Subject: B7 Design Review – 195 Kennebec Street

Written by: Caitlin Cameron, Urban Designer

Date of Review: Monday, March 16, 2015

SHEET TITLE: **SITE LAYOUT AND UTILITY PLAN**

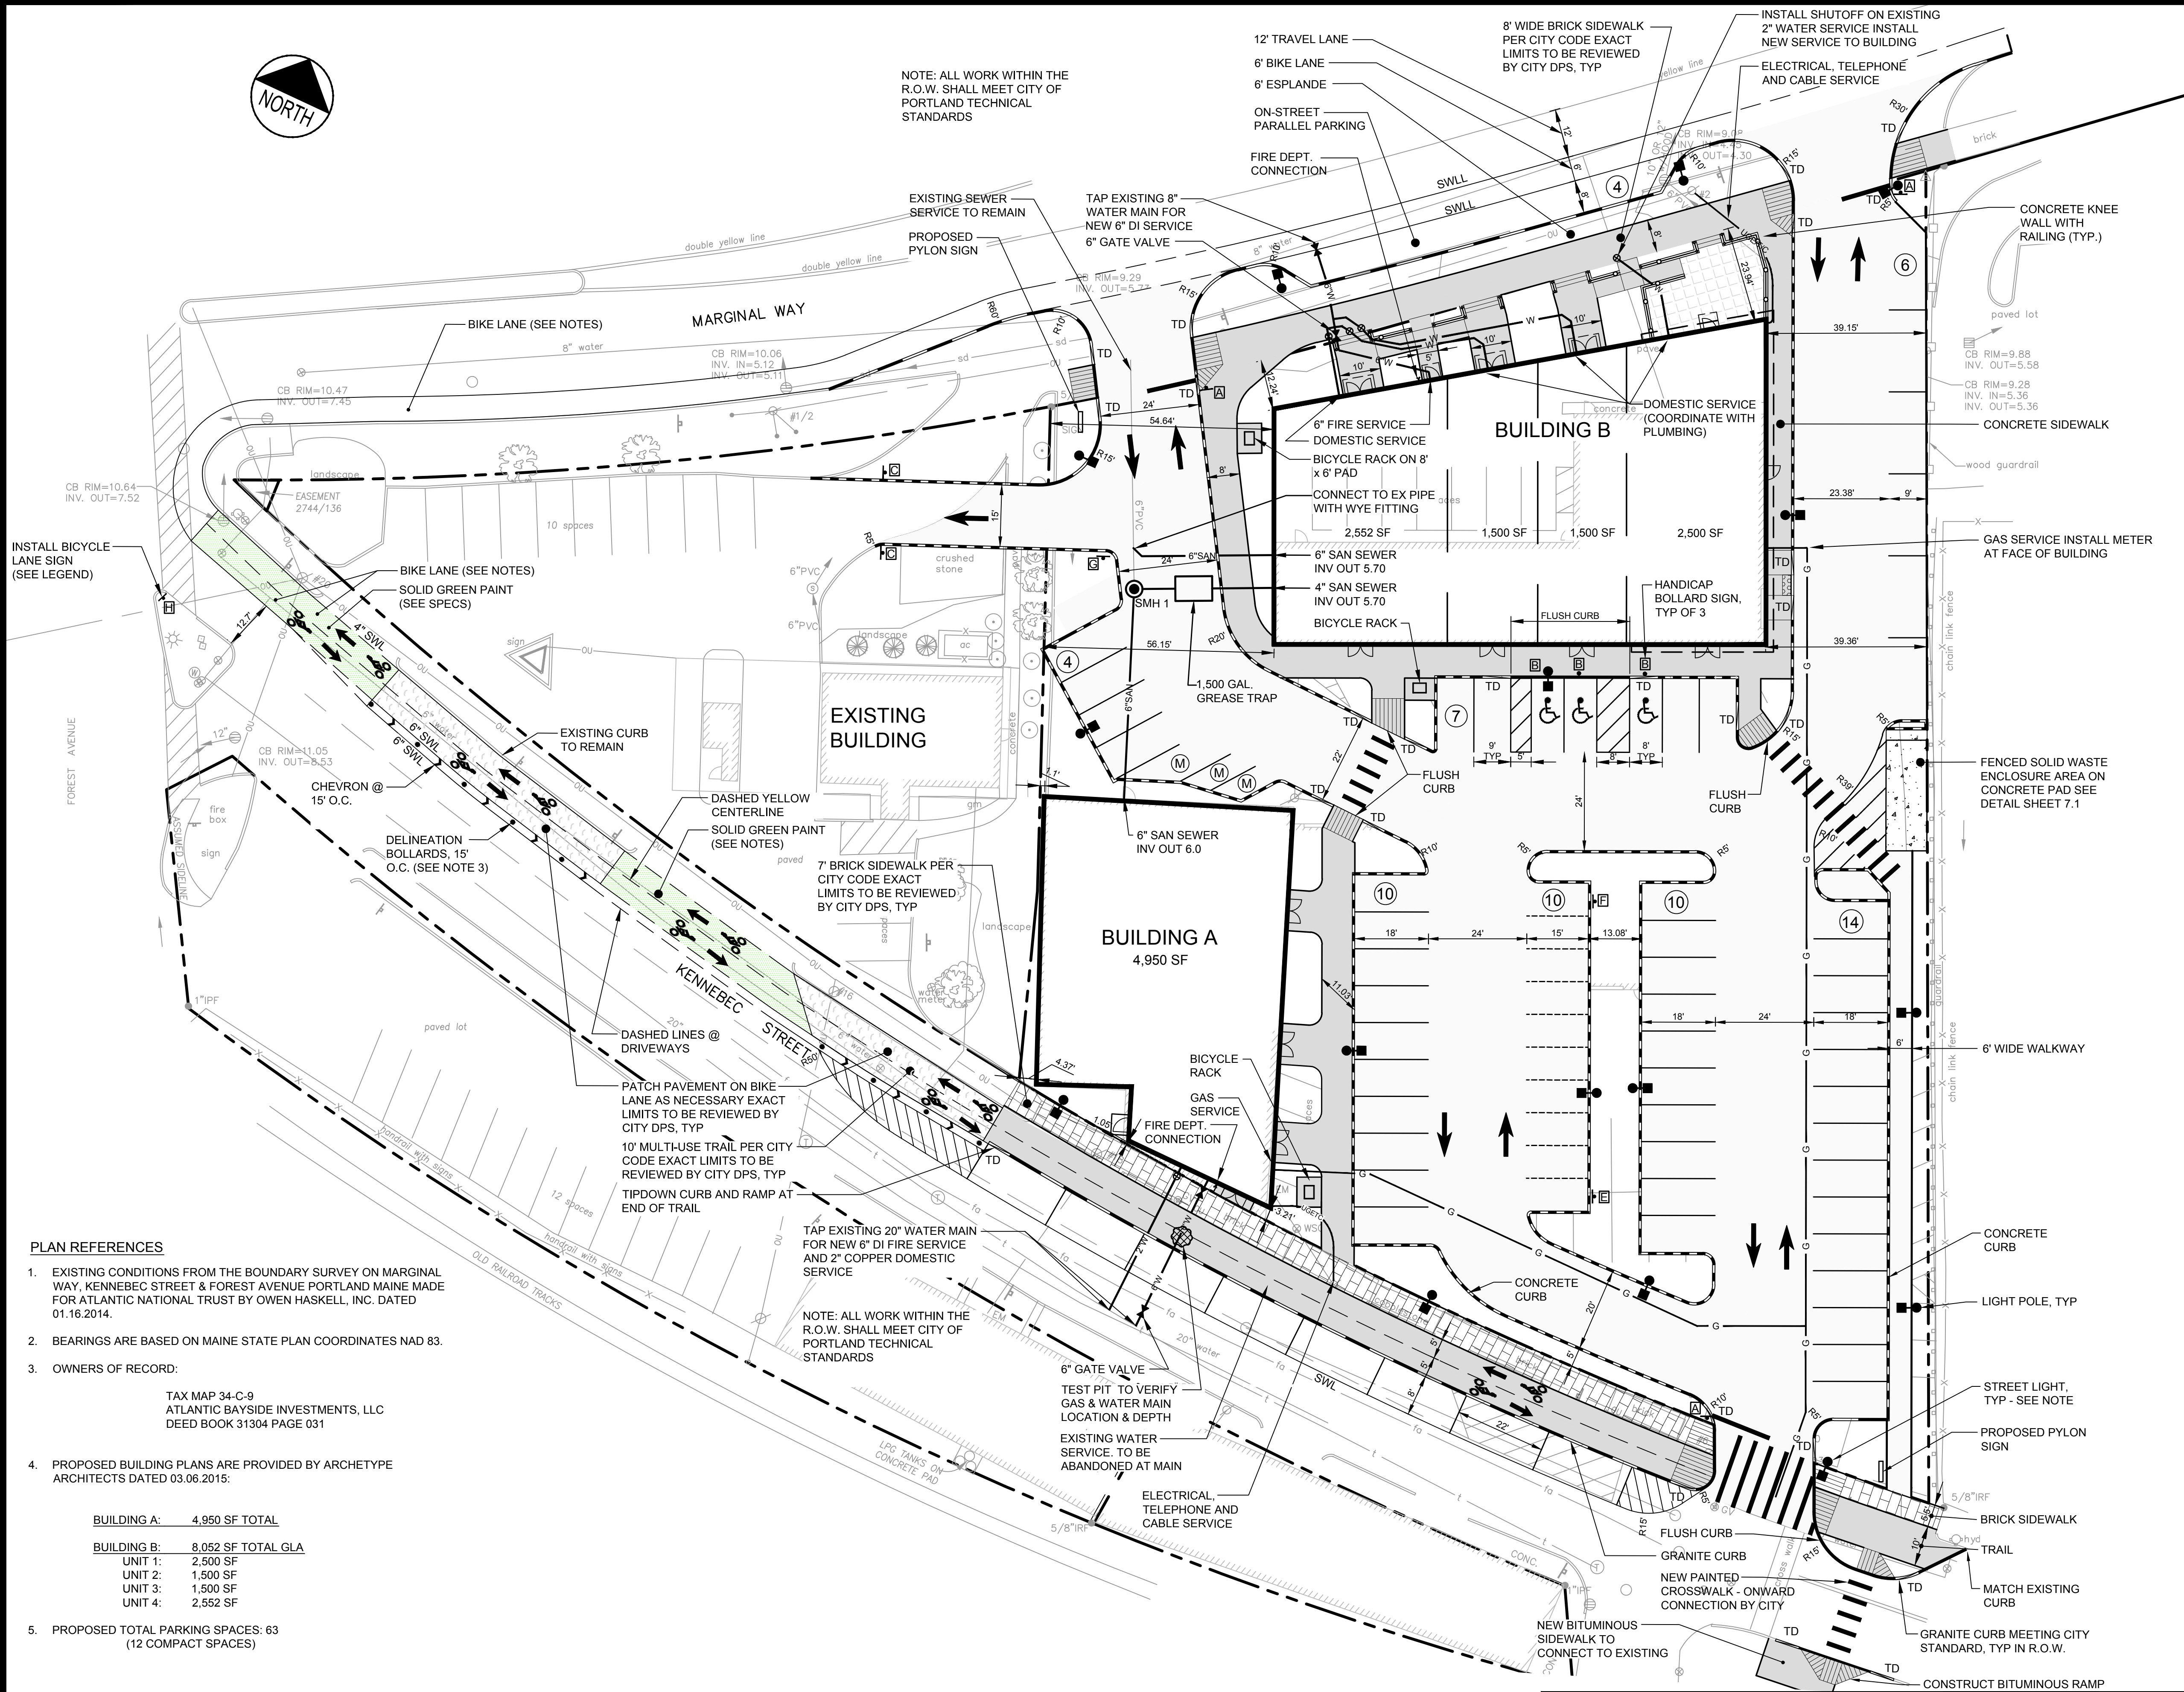
- **Direct pedestrian access through the eastern side of the site connecting Kennebec Street and Marginal Way will formalize existing desire lines and coordinate with existing crosswalk locations.**

- **Direct pedestrian access through the eastern side of the site connecting Kennebec Street and Marginal Way will formalize existing desire lines and coordinate with existing crosswalk locations providing a continuous travel corridor to modes in addition to automobiles.**

- **Please provide details and locations for street lights according to Site Plan and Technical Manual standards.**

24'-3" STREET LIGHTS TO CITY STANDARDS. LOCATIONS TO BE CONFIRMED.

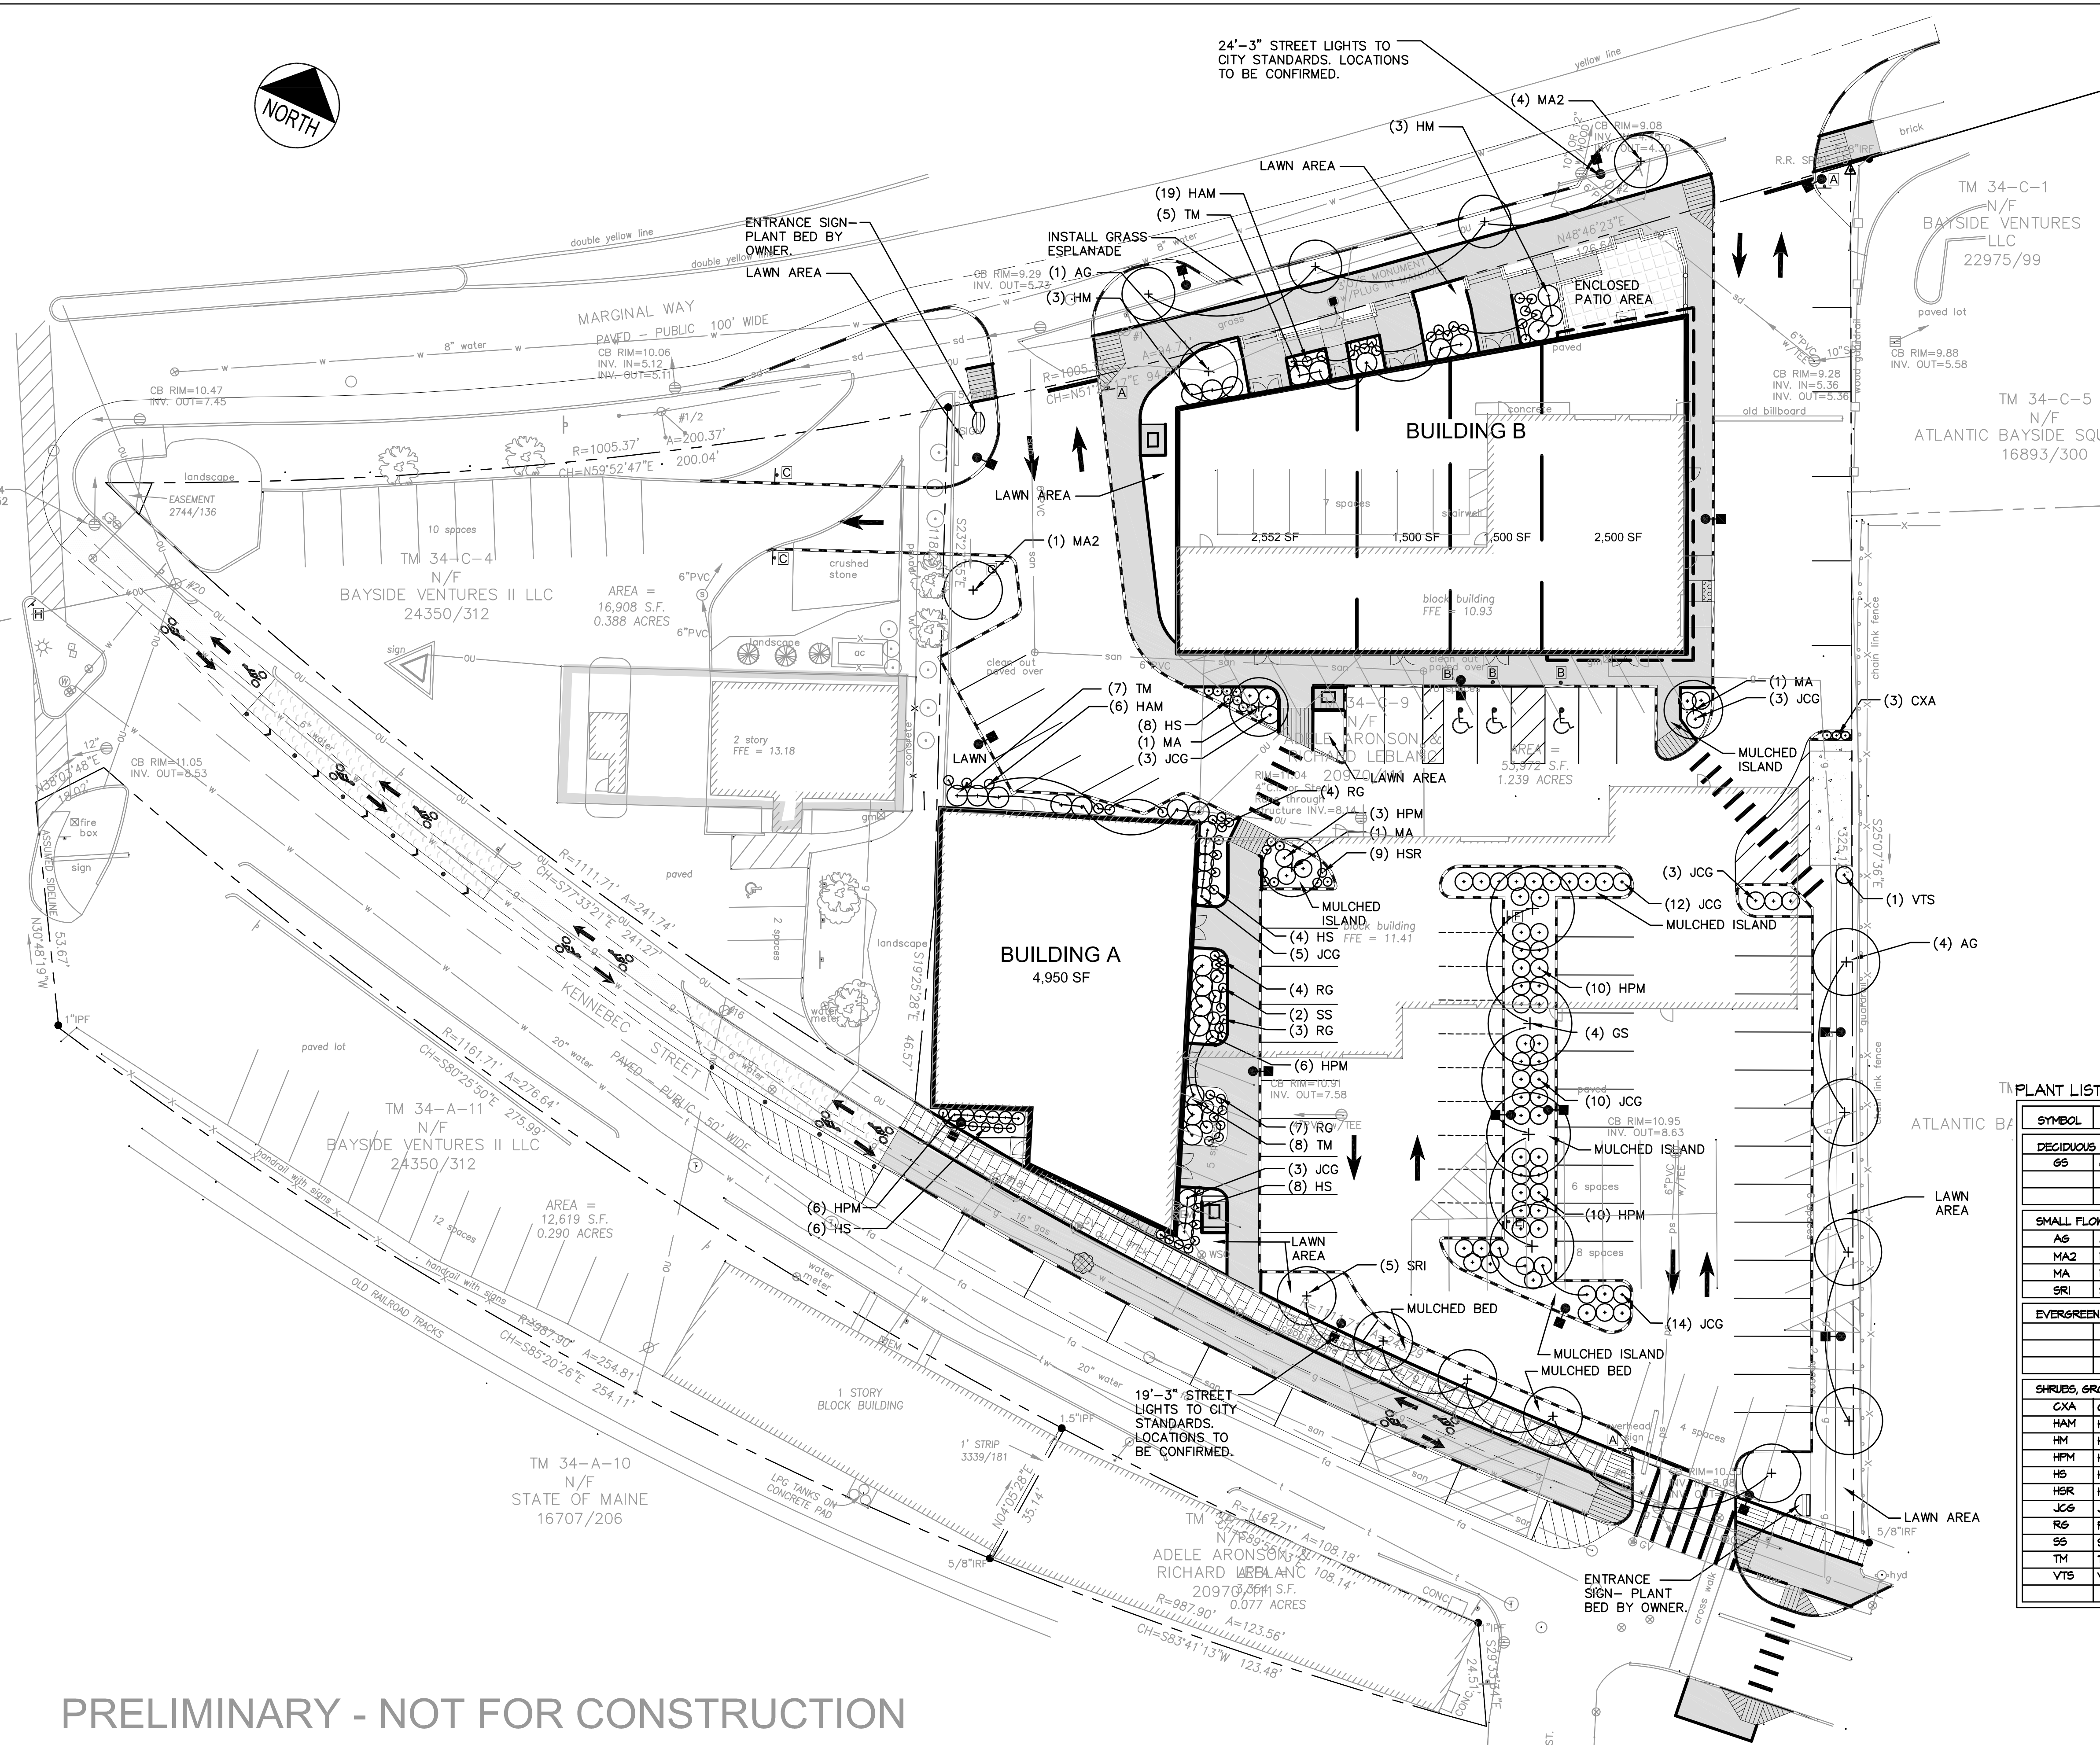
- **Building A does not incorporate any elements to enhance the pedestrian environment on Kennebec Street.**
- **Street lights and street trees are not currently shown in proposal.**

- **Please provide details and locations for street lights and street trees according to Site Plan and Technical Manual standards.**
